September 30, 2013
File: 13105

Ms. Jean Fraser
City of Portland
389 Congress Street, 4th Floor
Portland, ME 04101

RE: 133 YORK STREET
RESPONSE TO DAVID SENUS, P.E., MEMO DATED AUGUST 27, 2013

10 TREE FILTER DETAILS

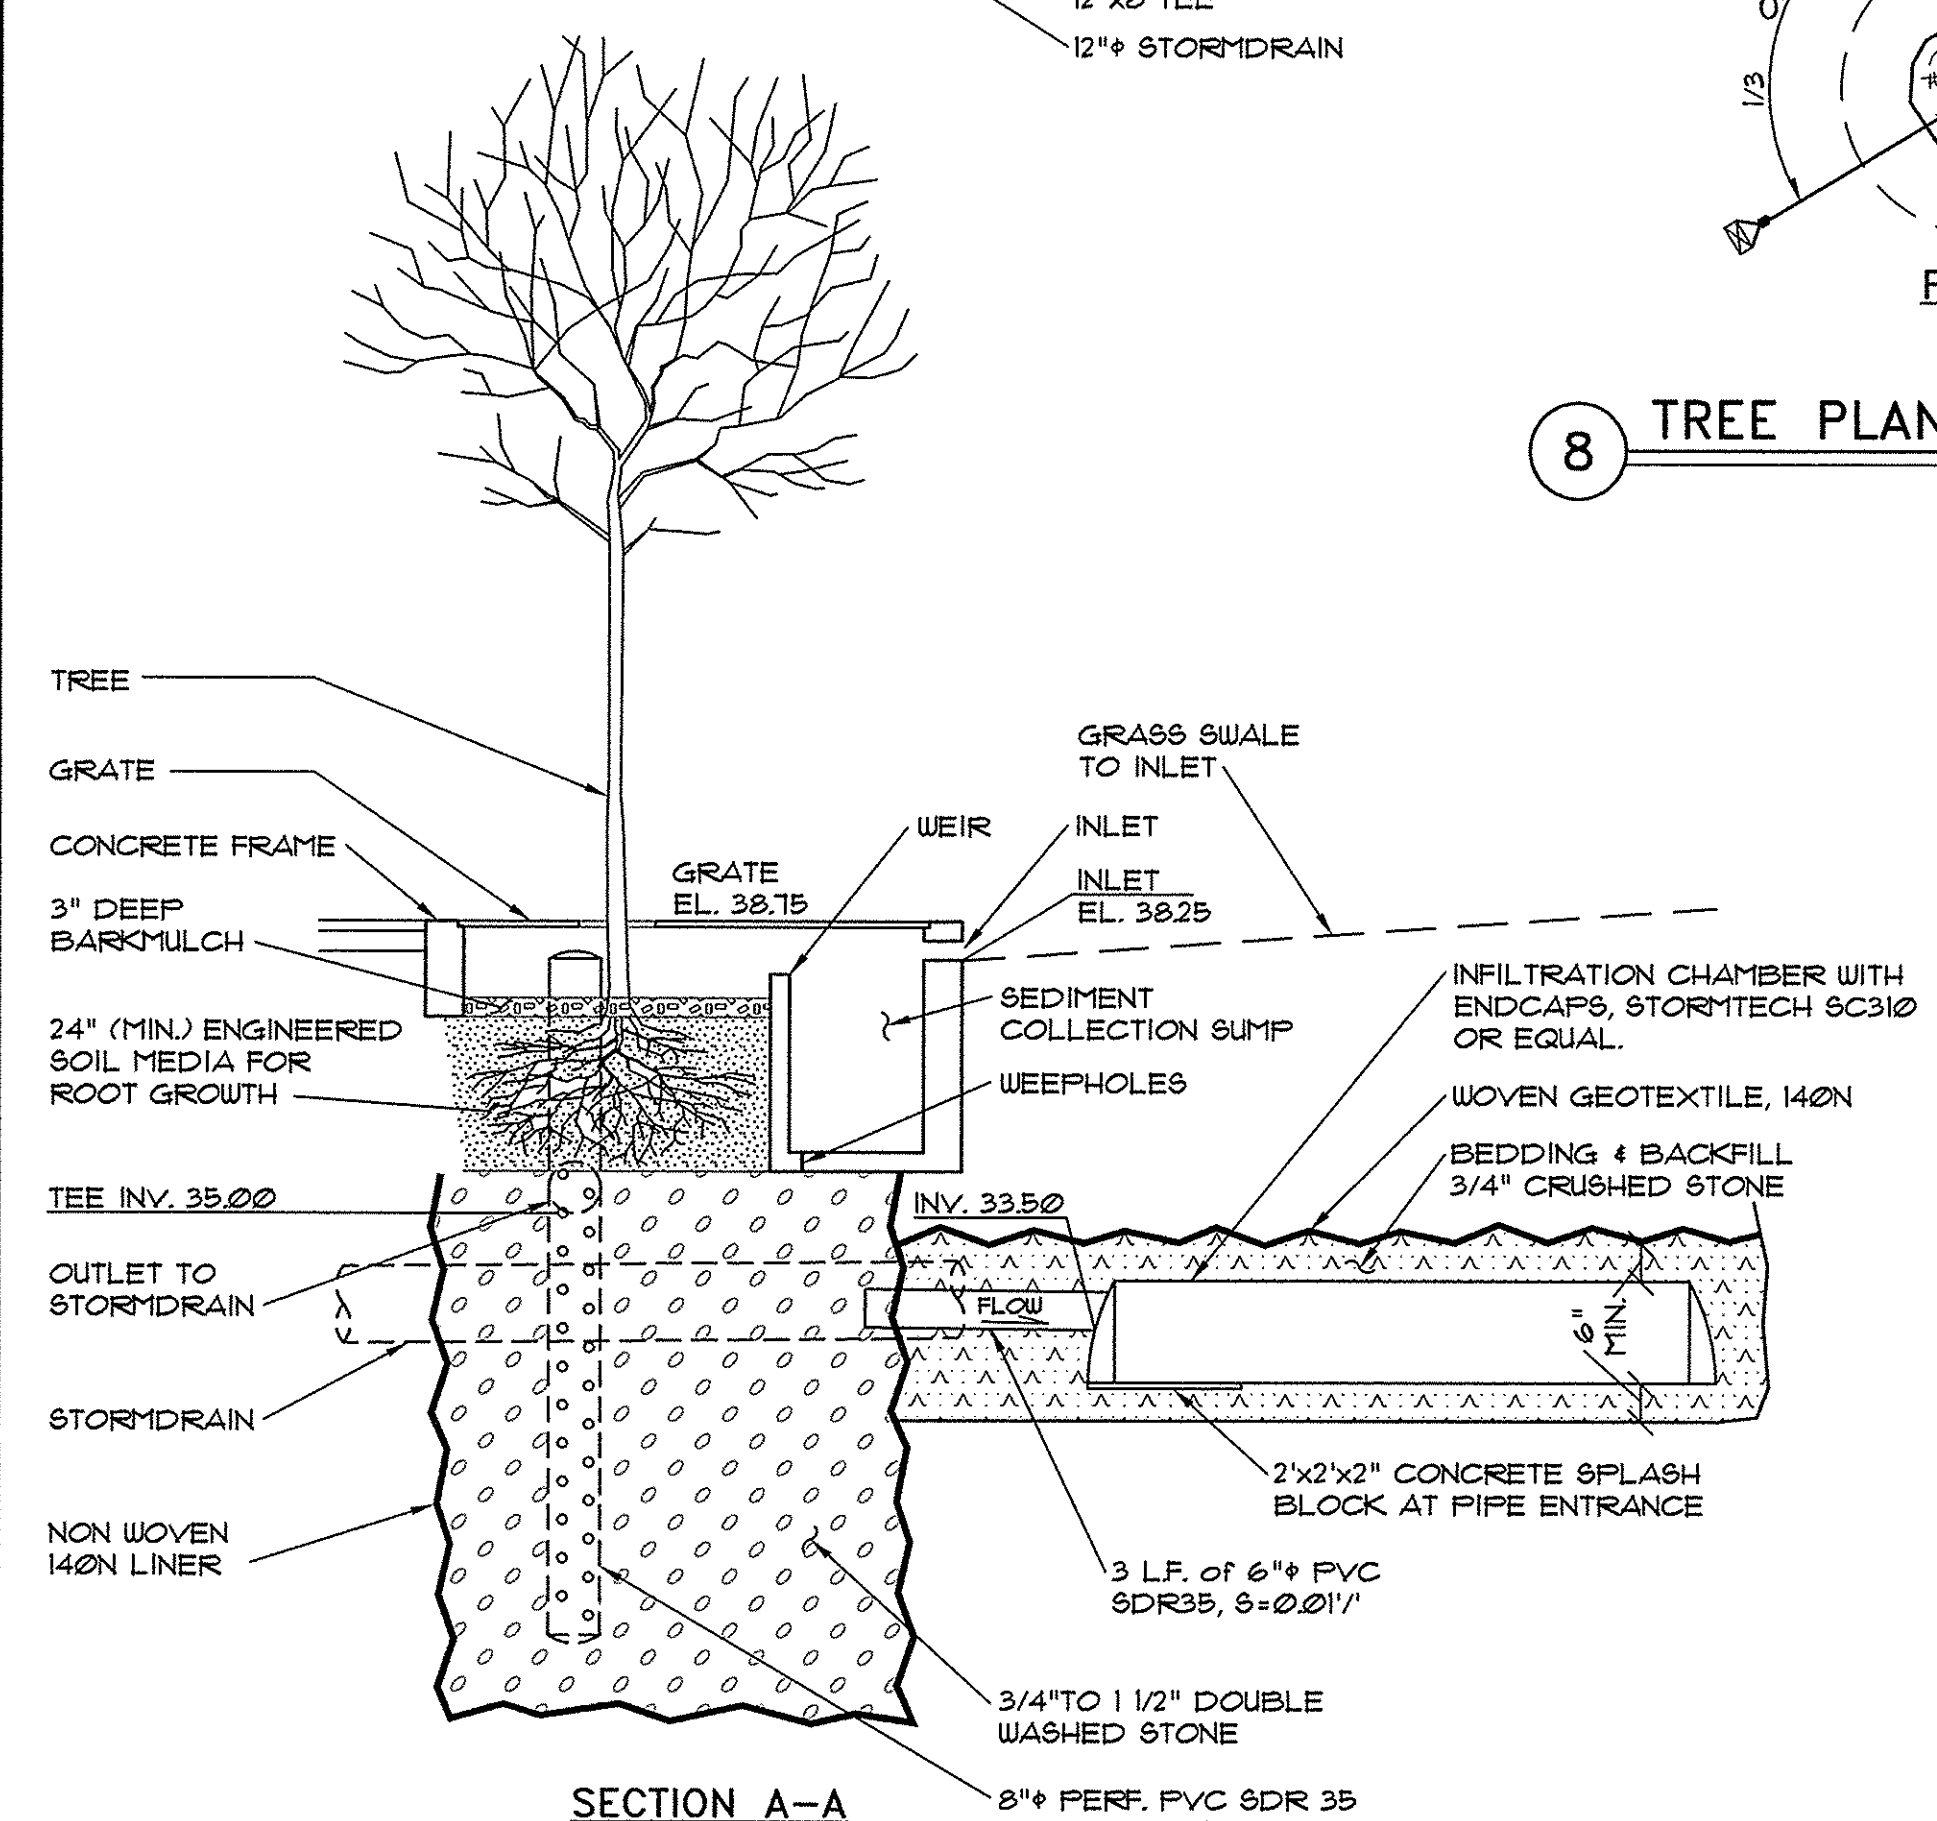
b) *General Standard: The Applicant has proposed a stormwater tree well to treat runoff from an impervious area in excess of the proposed new impervious area; the approach meets the intent of the General Standards. The Applicant should provide calculations on the sizing and design of the tree filter system, and clarify the system dimensions on Tree Filter detail sheet.*

4. *Provide additional information related to the roof drain connection to the treewell filter and the treewell filter connection to the site's storm drain system (provide pipe sizes, invert elevations, and detail the connections to the tree filter).*

We have added details on the tree filter to the drawings. We have removed the roof drain from the filter at the recommendation of Tree Filter's manufacturer. Attached are calculations for the tree filter.

The details of the drainage connections have been provided.

C1.1

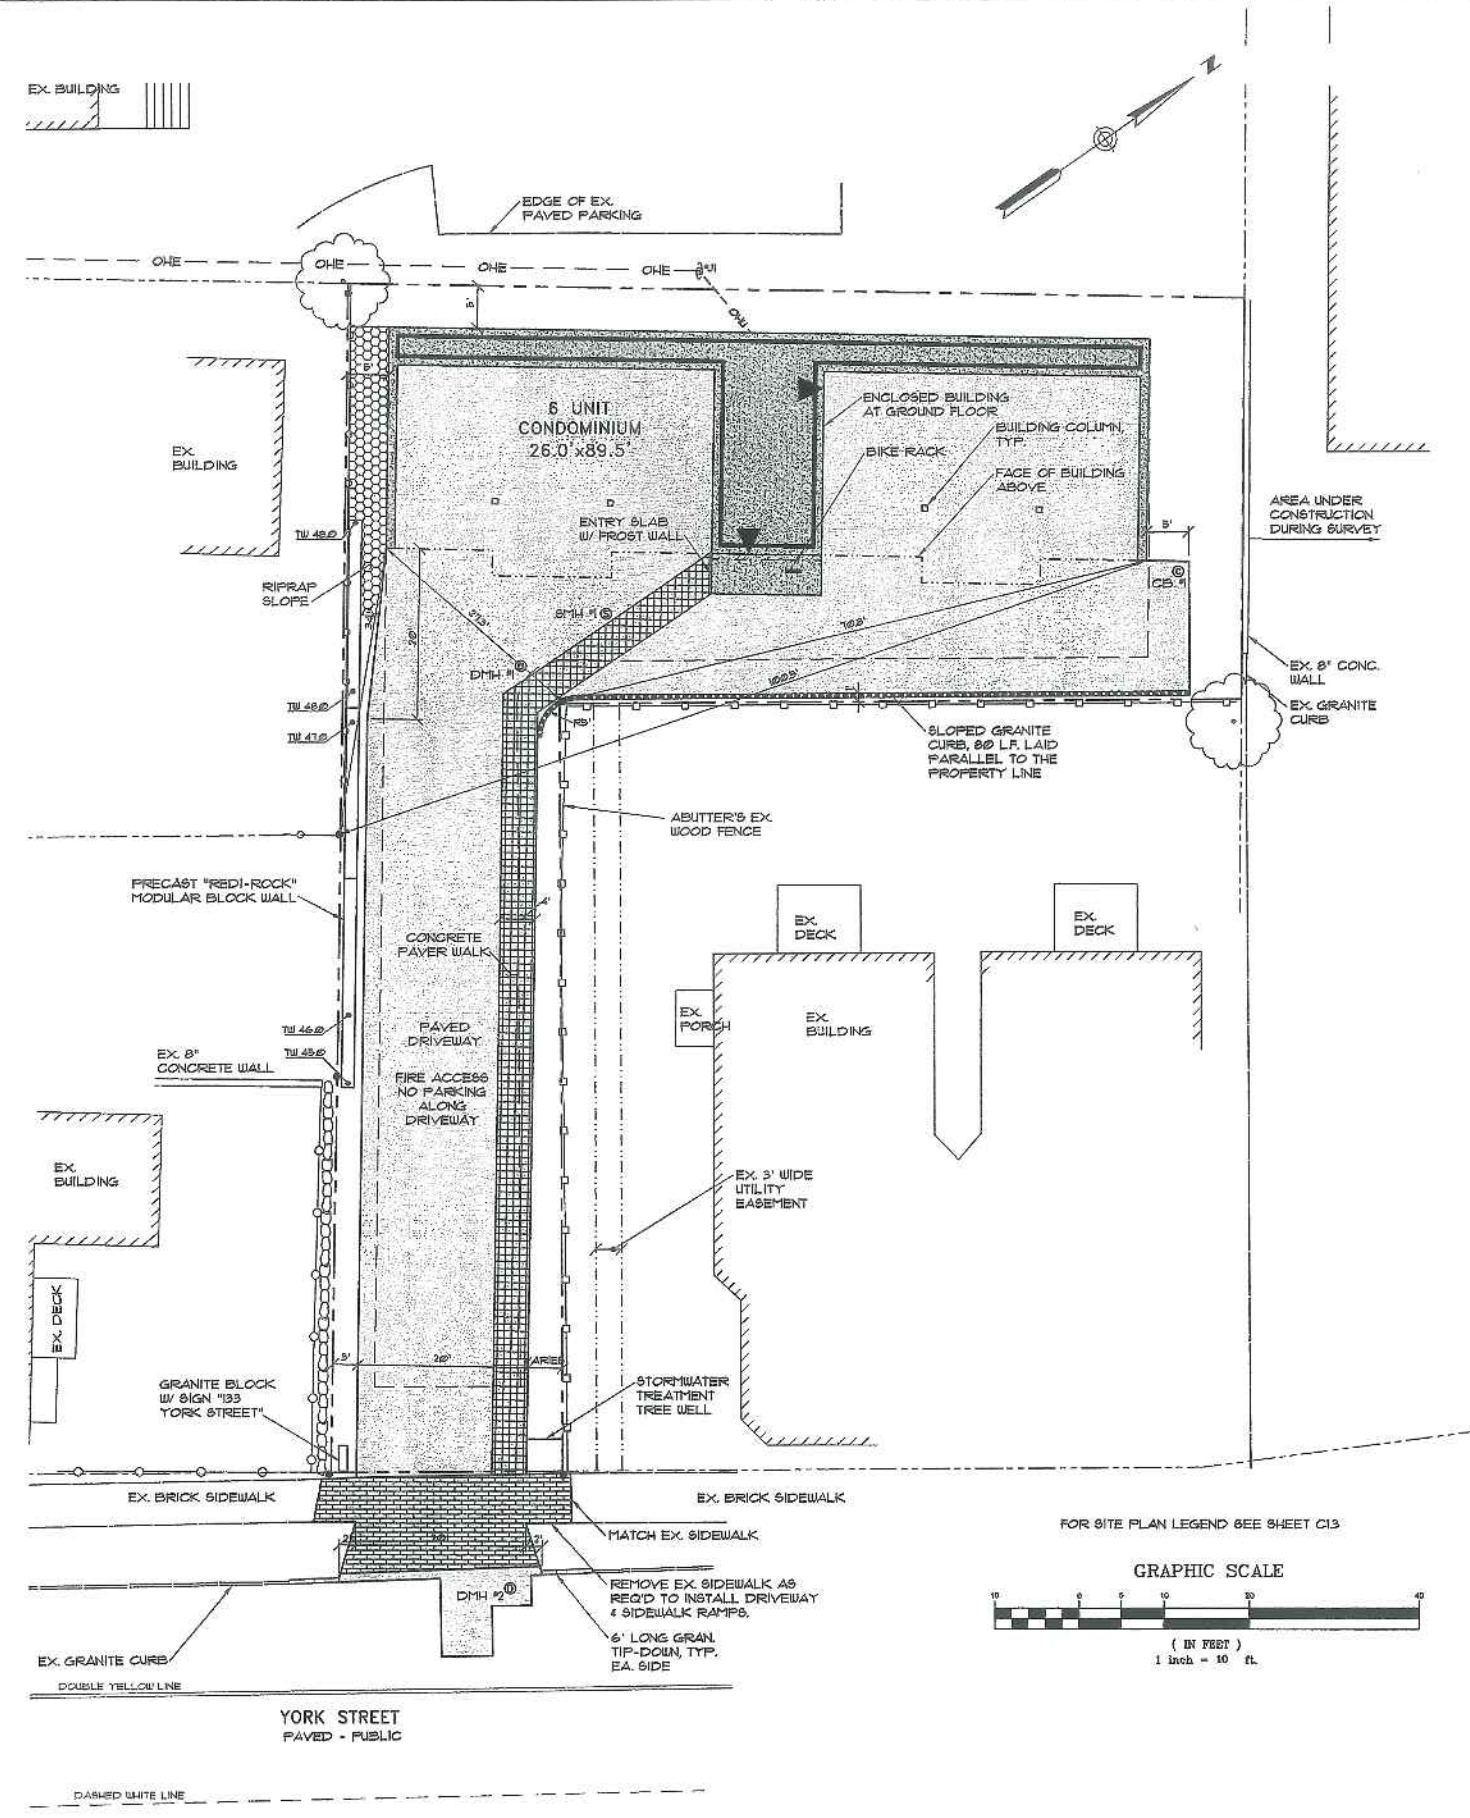
6. *Note 3 on C1.1 states that "All Powerline Utilities Shall Be Overhead"; however, a note on C1.3 indicates an underground connection from the utility pole at the rear of the building; please clarify. In addition, it appears that an easement will be required from McCormick Place Condominium for this underground utility connection.*

The existing utilities access the site in that location.

C1.3

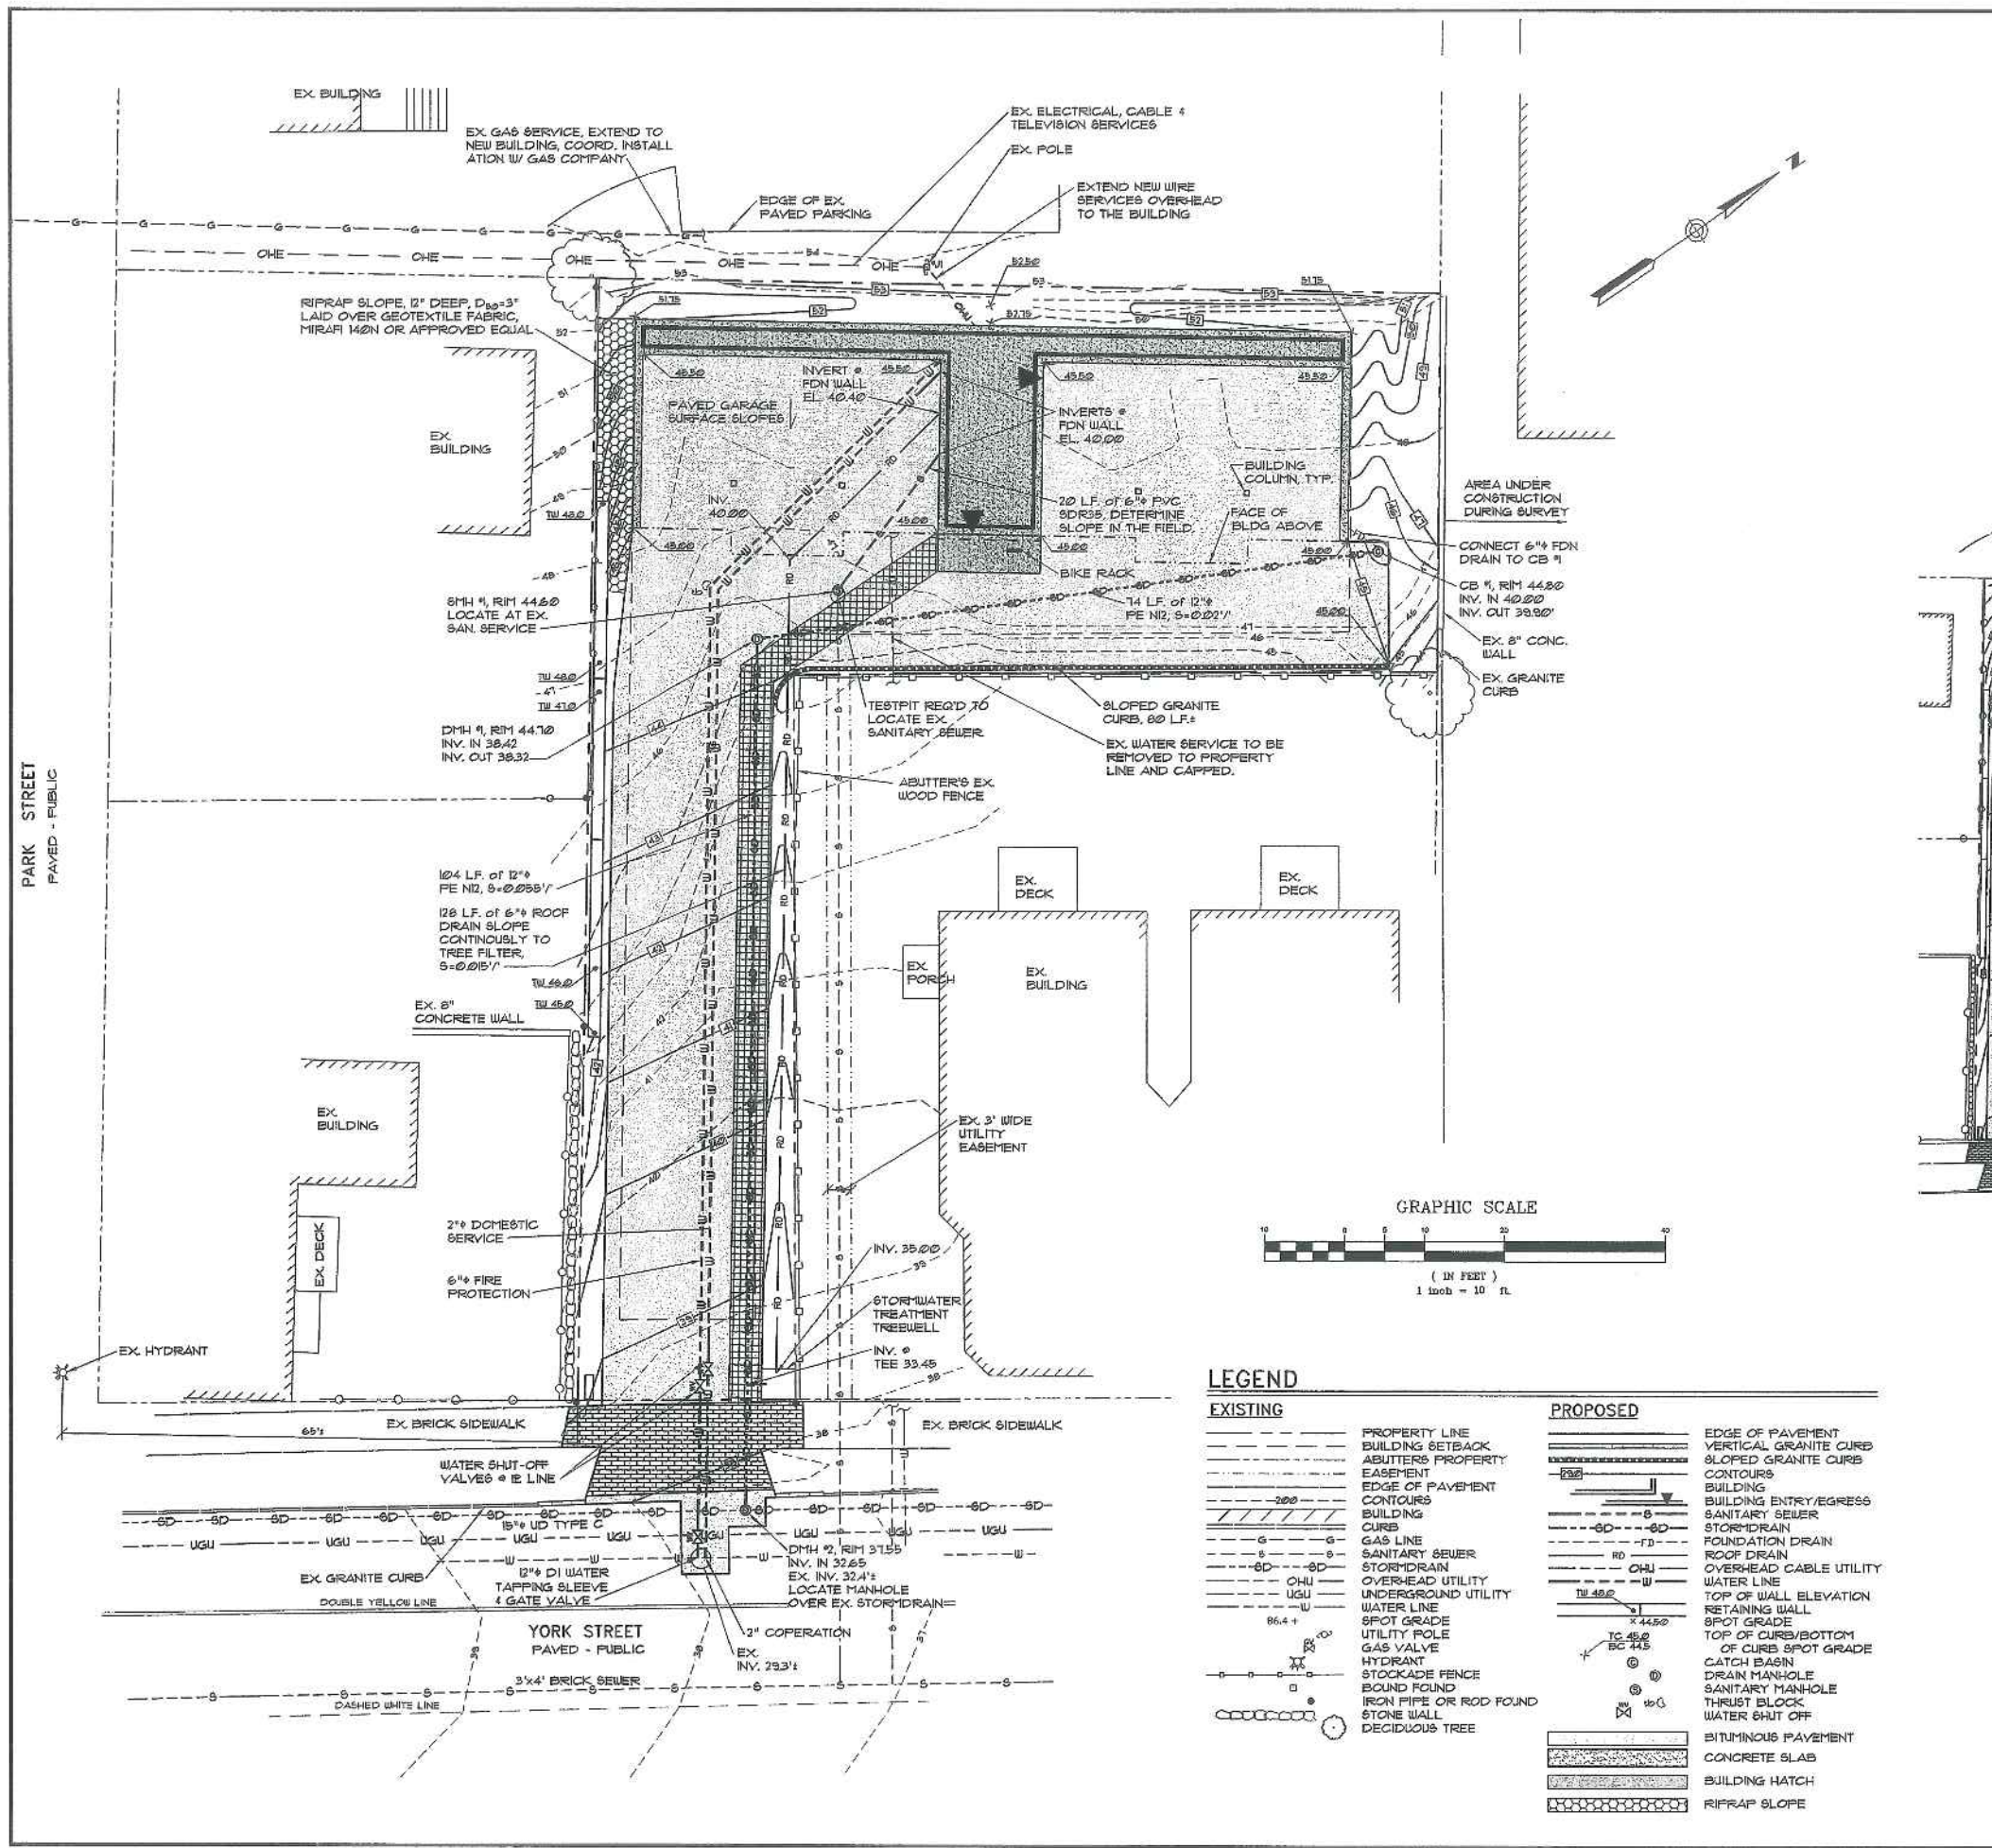
5. *Proposed topography on C1.3 indicates that a portion of the drainage from uphill lots will be routed directly along the west building wall, please review the grading in this area.*

The grading is correct. There are openings in that wall required by code that prevent grading away from the building. We have ripped the area to provide a stable surface.
